SSD-10367 – PROPOSED UNDERGROUND MINING OPERATION & DA14/98-MOD 16 – CHANGES TO EXISTING OPEN CUT MINING OPERATION TO SUPPORT PROPOSED UNDERGROUND MINING OPERATION, COWAL GOLD MINE.

I refer to your correspondence regarding the subject Application which was referred to Transport for NSW (TfNSW), formerly Roads and Maritime Services, for assessment and comment.

Photographs of the existing intersection at Newell Highway and West Plains Road

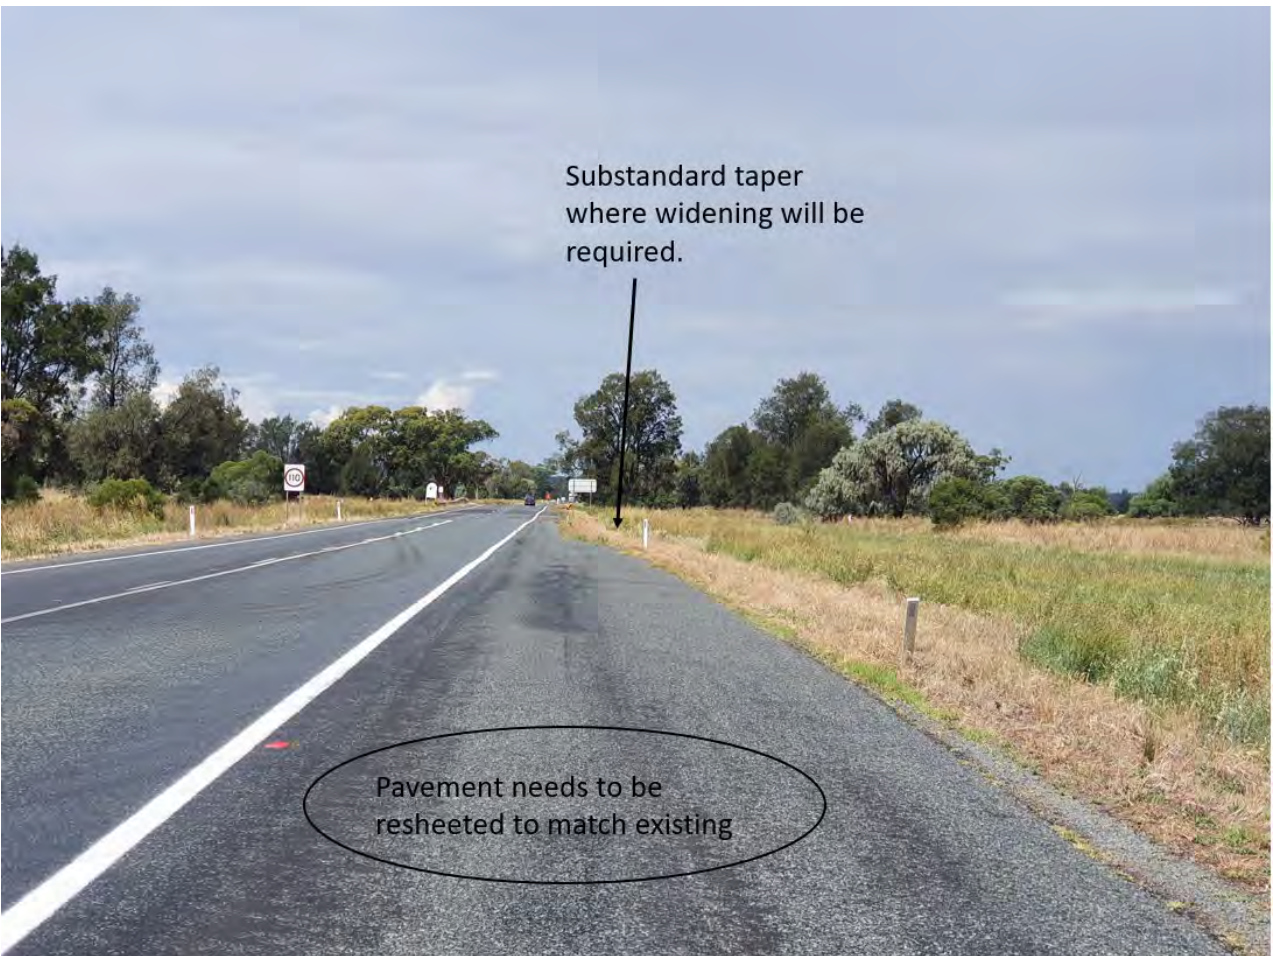
The preferred route from Forbes includes the intersection of West Plains Road with the Newell Highway. This intersection is located on the Newell Highway, which is a road train route, within a

110 kmh speed zone. The submitted report does not address the current standard of this intersection. As this intersection with the Newell Highway is located within a high speed road environment and will experience an increase in traffic volumes it is considered appropriate that it be constructed to provide a Basic Right Turn (BAR) and Basic Left Turn (BAL) intersection treatment for road safety reasons.

1. The intersection of the Newell Highway with West Plains Road shall be constructed as a Basic Right Turn (BAR) and Basic Left Turn (BAL) intersection treatment within the Newell Highway. The design and construction of the intersection treatment shall be in accordance with the Austroads Guide to Road Design as amended by the supplements adopted by Transport for NSW for the posted speed limit and be designed for a road train route. The pavement standards are to be in accordance with the requirements of Transport for NSW for the proposed turning traffic.

2. An audit of the existing intersection treatment as constructed is to be undertaken by an appropriately qualified person to assess the compliance of the existing intersection with the required treatment and the integrity of the existing pavement to cater to the expected turning traffic volumes and the through traffic along the Newell Highway. Should the intersection not comply with these requirements the intersection and pavement treatment is to be designed and constructed to comply with the adopted standards.
